Subject: Shoreline Exemption Permit, Pump Station 16 – 5495 W. Mercer Way

This is a written response to the review comments provided by the Community Planning and Development Department regarding the application for the Shoreline Exemption Permit, SHL23-004, for Pump Station 16 located at 5495 W. Mercer Way.

PUMP STATION 16 - 5495 W. MERCER WAY

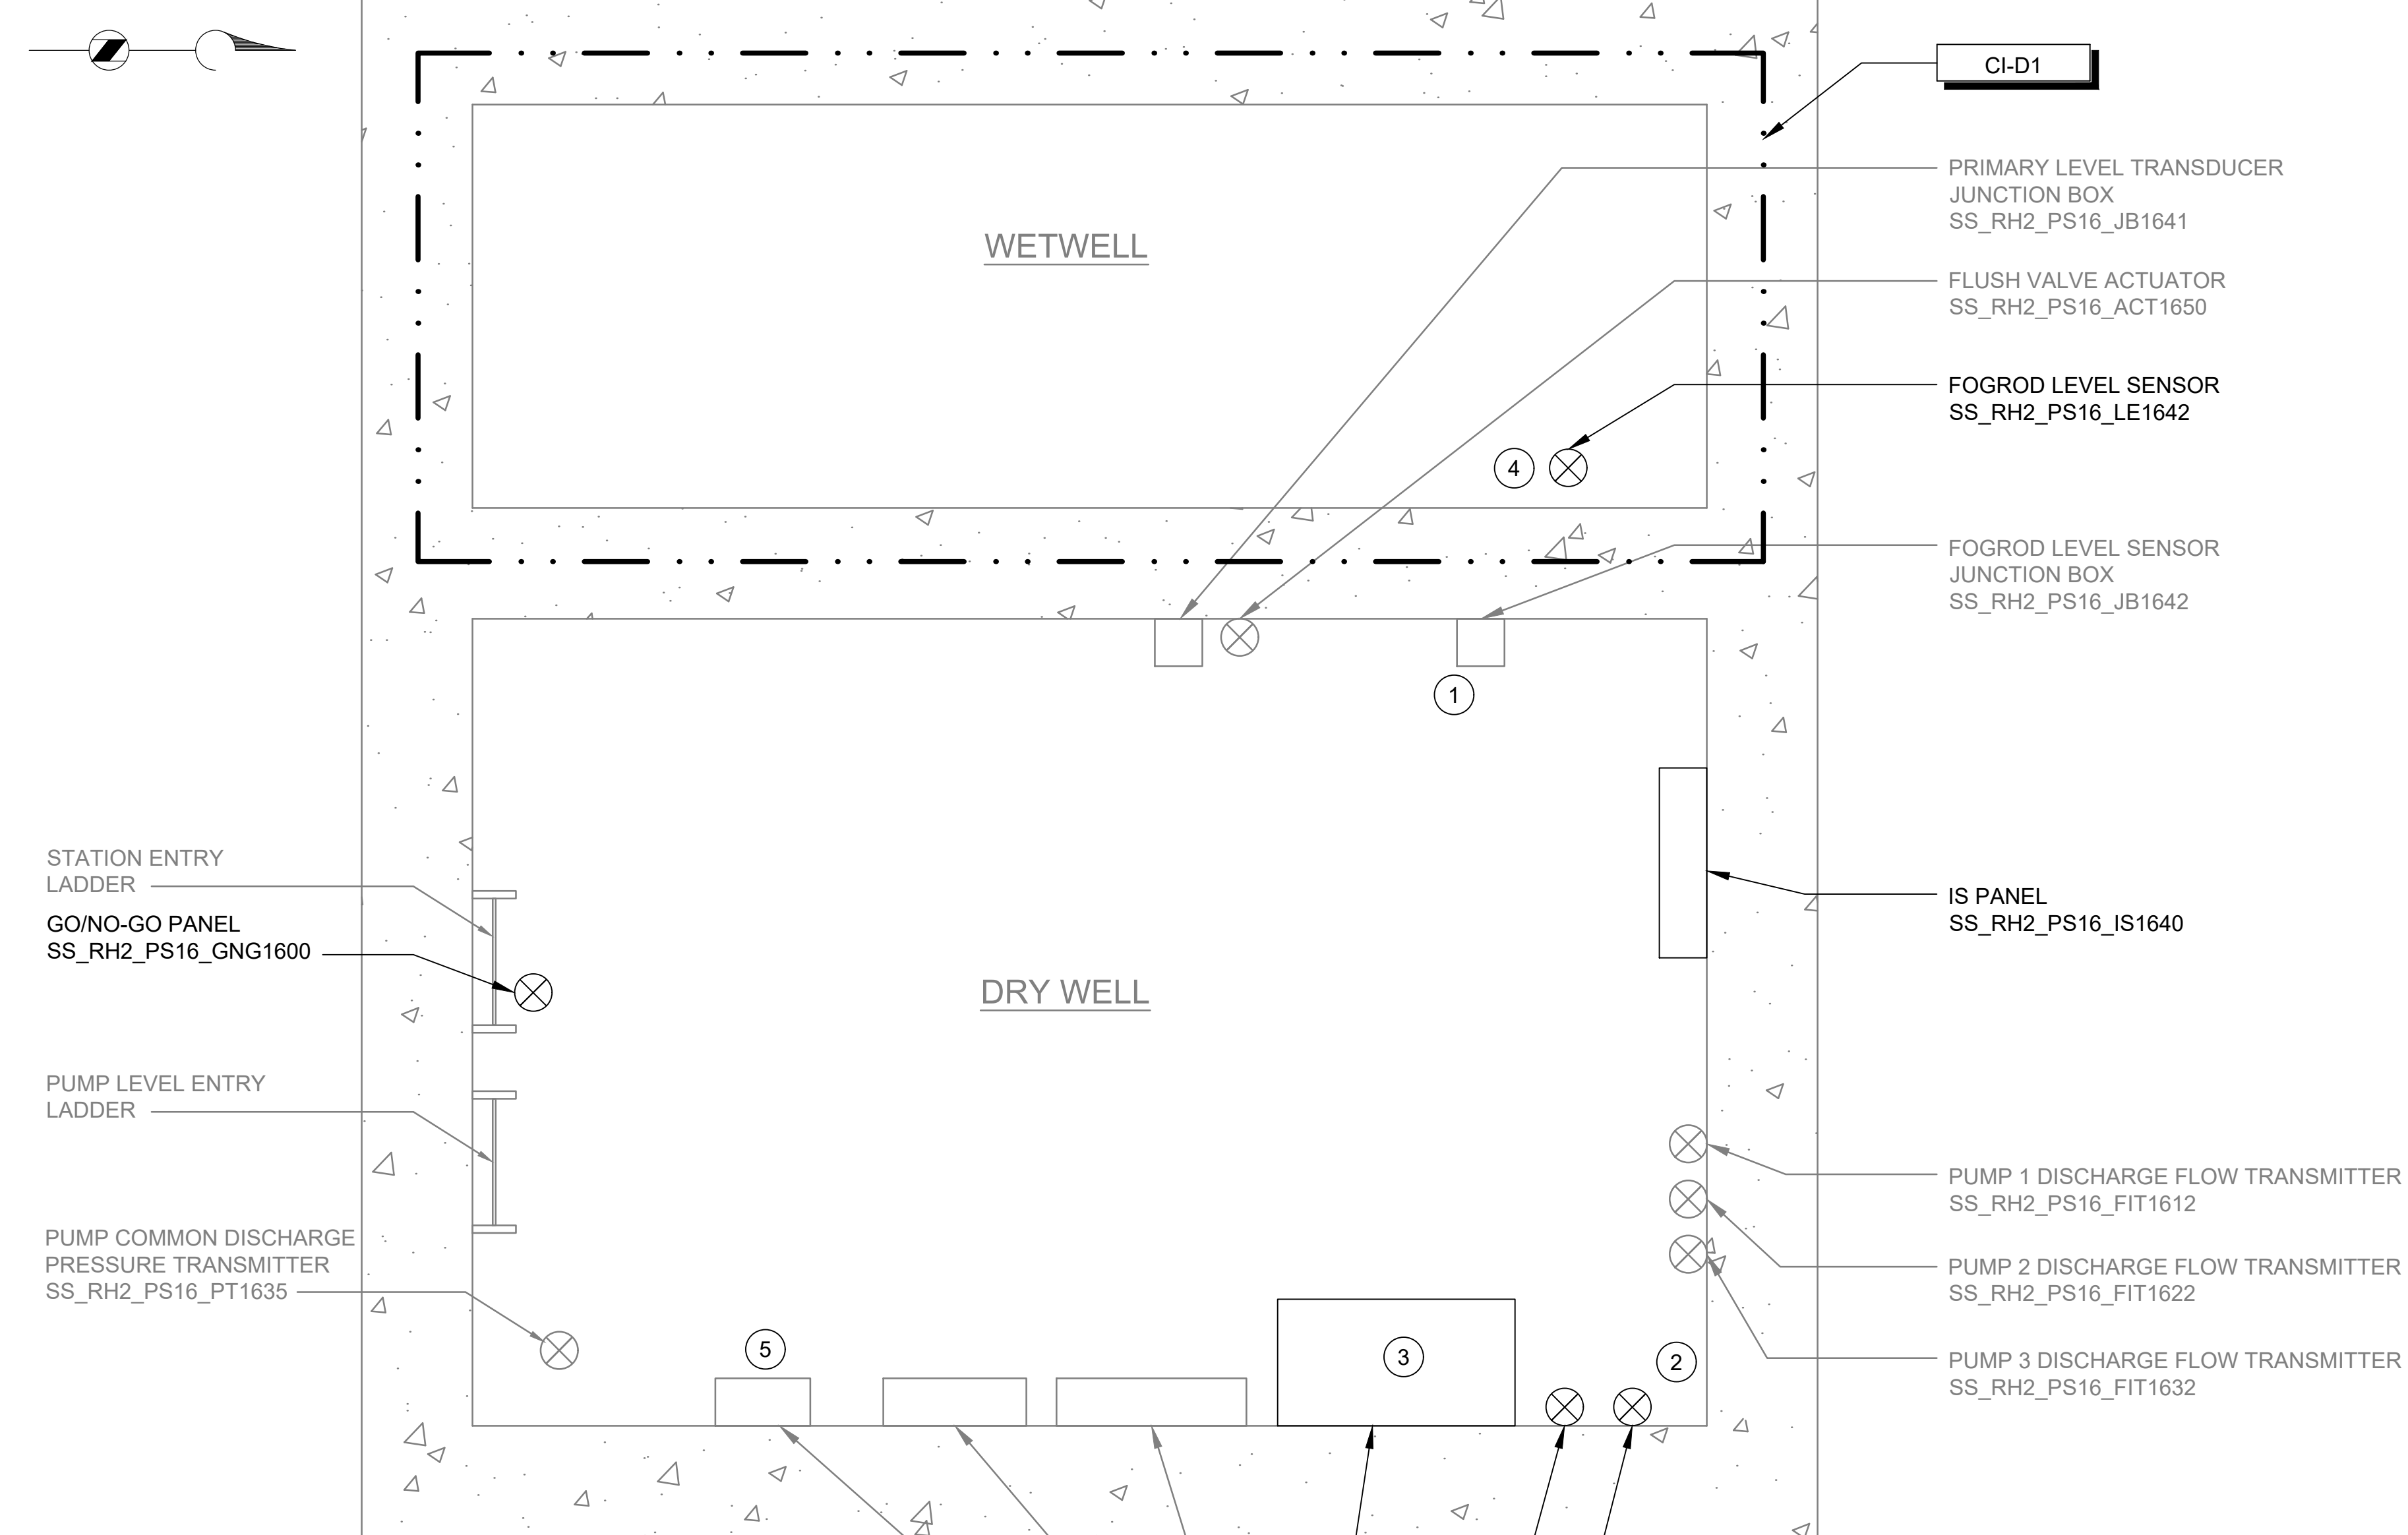
- a. Provide address of all pump stations on plans

Response: *The address for the pump station has been added to Development Plan, Instrumentation Drawing page 1. The address was also included in the aerial photo of the pump station.*
